Application number: 2020/93954	
What is the application for?:	Erection of 57 dwellings and associated works
Address of the site or building:	Land at, Lingards Road, Slaithwaite, Huddersfield, HD7 5HY
Postcode:	HD7 5AL

Type of comment: An objection
Our main concern is still that the increased housing density and design of the development are not consistent with the rural fringe location and will have a significant adverse impact on existing properties bordering the site. In 2015 the site was granted outline planning permission for 27 dwellings (not 33 as indicated by the developer in his documents). This did not include any flats or three storey buildings. In 2019 the Local Plan indicated 36 dwellings, for a slightly larger site, now incorporating the small field behind numbers 37 to 43 Lingards Road. We are dismayed that the current plan is for 57 dwellings, including 20 flats, with most of them three or four storeys high. This marked increase in housing density is unacceptable. We have had a preliminary look at the plans and have identified these factors • The overall layout and design does not reflect the sensitive location, on a steeply sloping Pennine hillside immediately adja

SECTION P-P

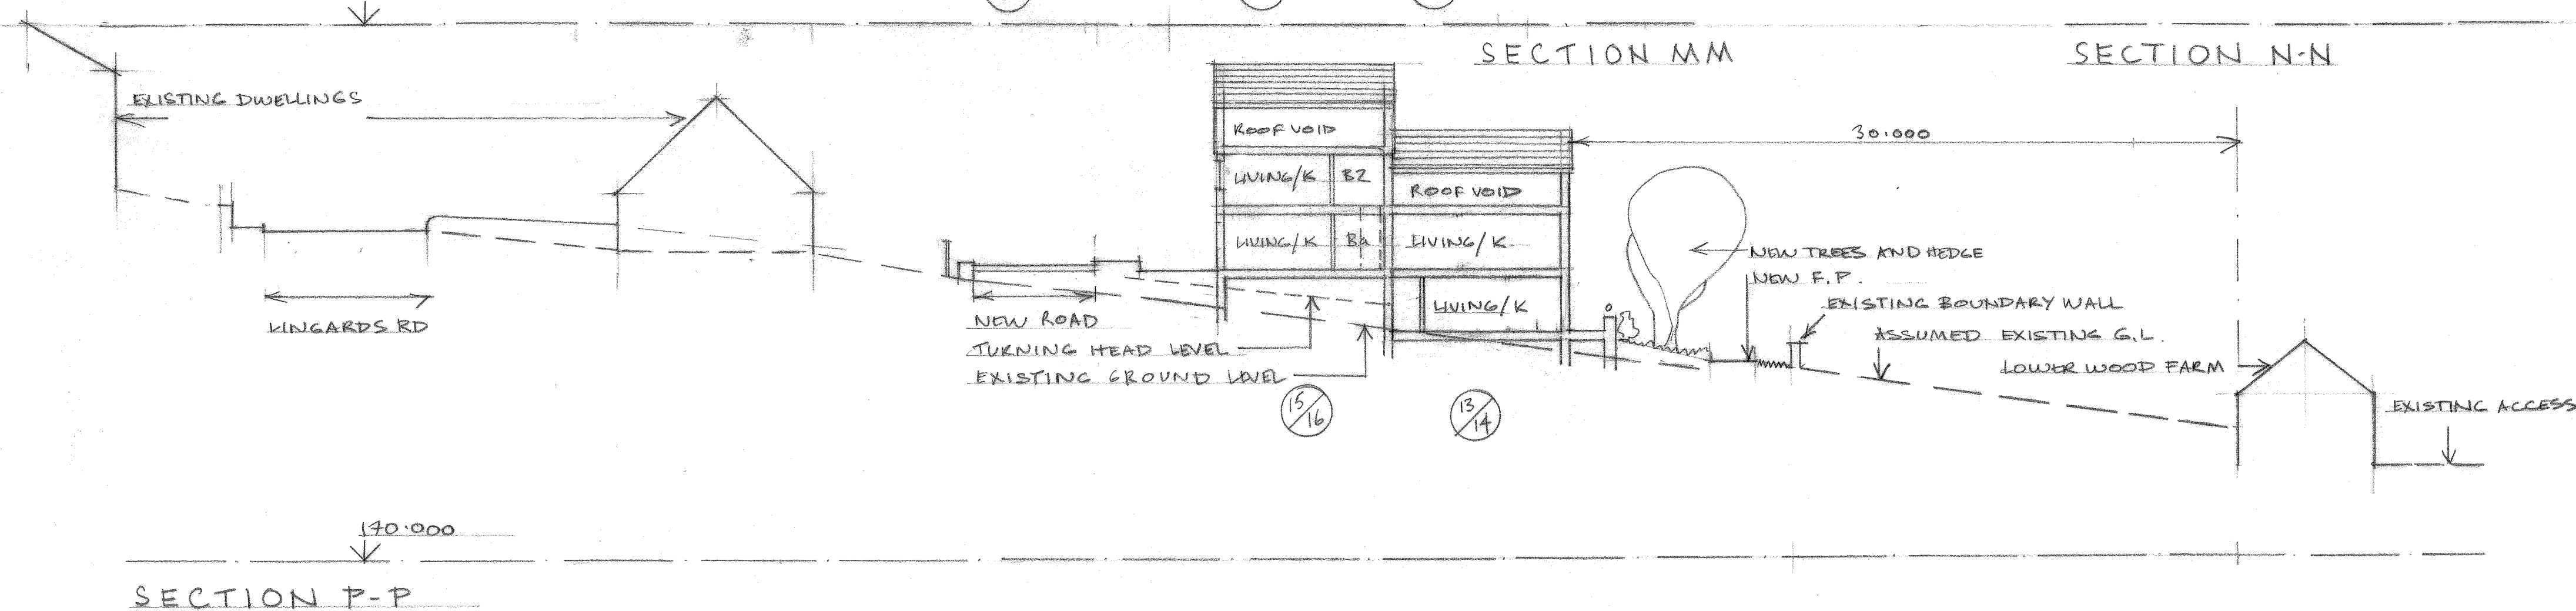
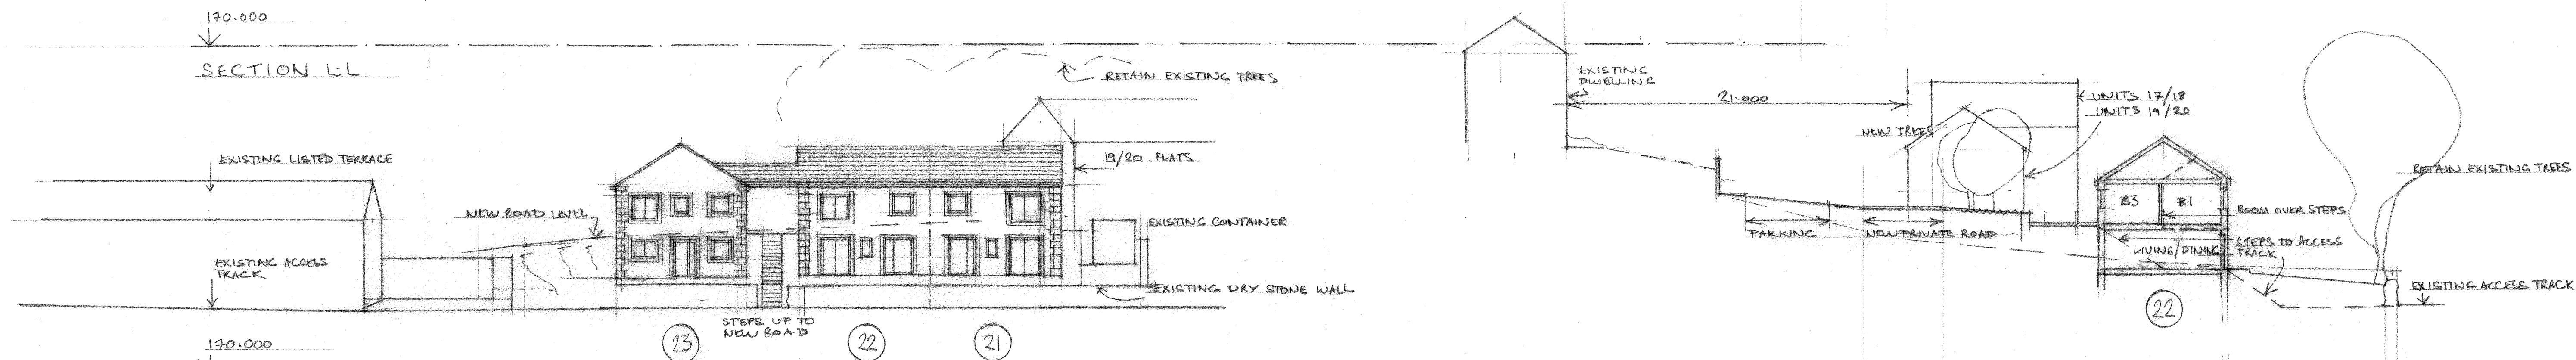
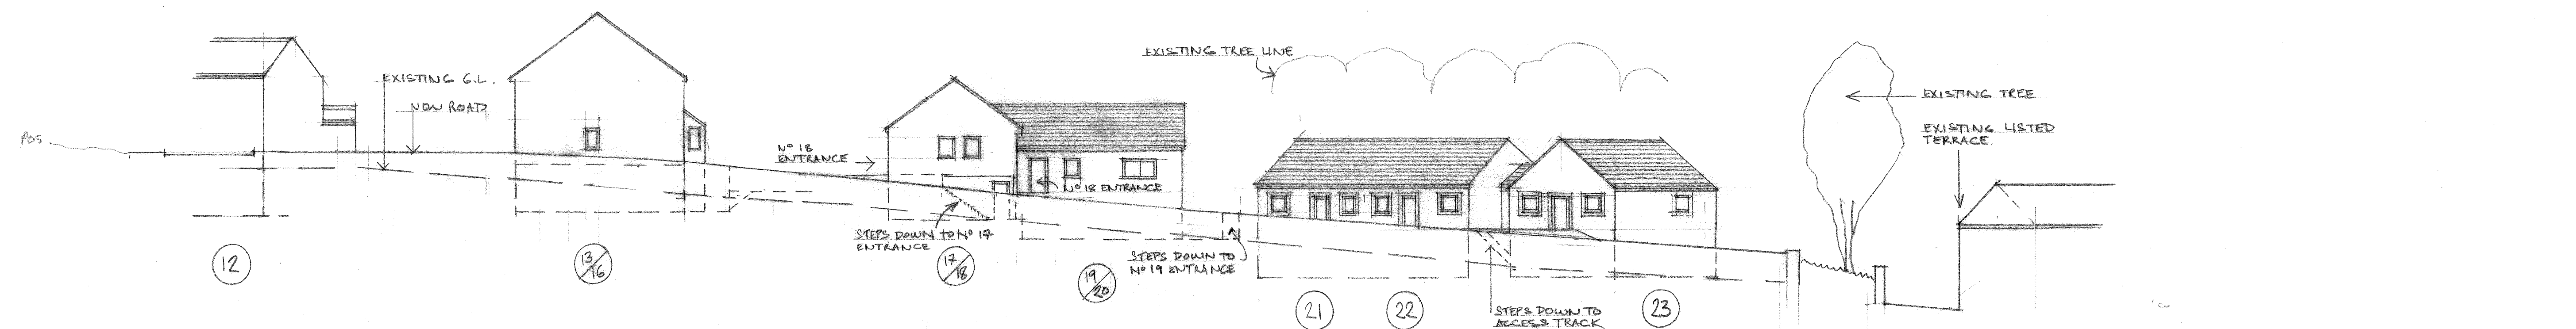
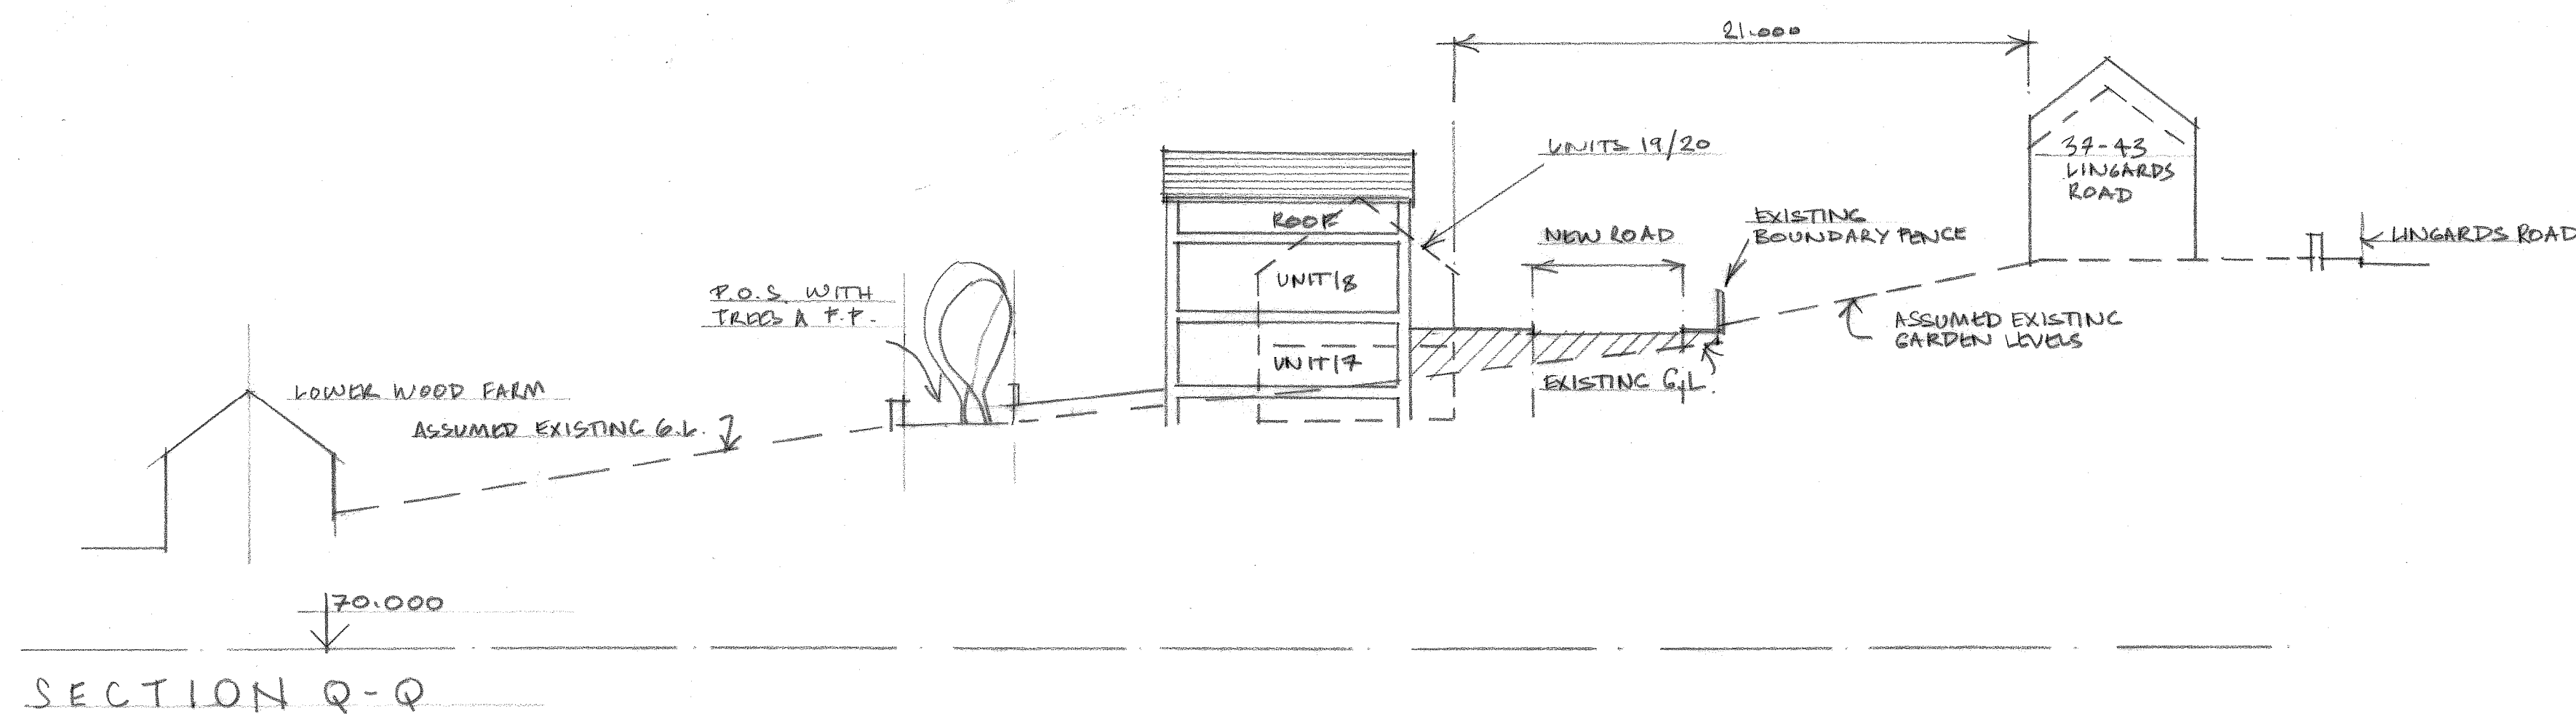
• The layout and levels of the proposed properties significantly harm the setting of the grade 2 listed buildings at Lower Wood Farm, contrary to explicit Local Plan and National Planning Policy Framework heritage protection requirements. NB: The ground floor level of the adjacent new properties is higher than the roof ridge line of the farmhouse!!

• The development has an unacceptable dominating impact, with severe over-looking and loss of privacy issues for properties on Manchester Road, the lower end of Lingards Road and Lower Wood Farm. To quote one worried resident on Manchester Road "it will be like a mill wall towering over us". The developer says in his application "To the north of the scheme further down the site the rear facades of the dwellings along Manchester Road look into their steep gardens and the steep bank beyond therefore any impact is minimal." We do not agree.
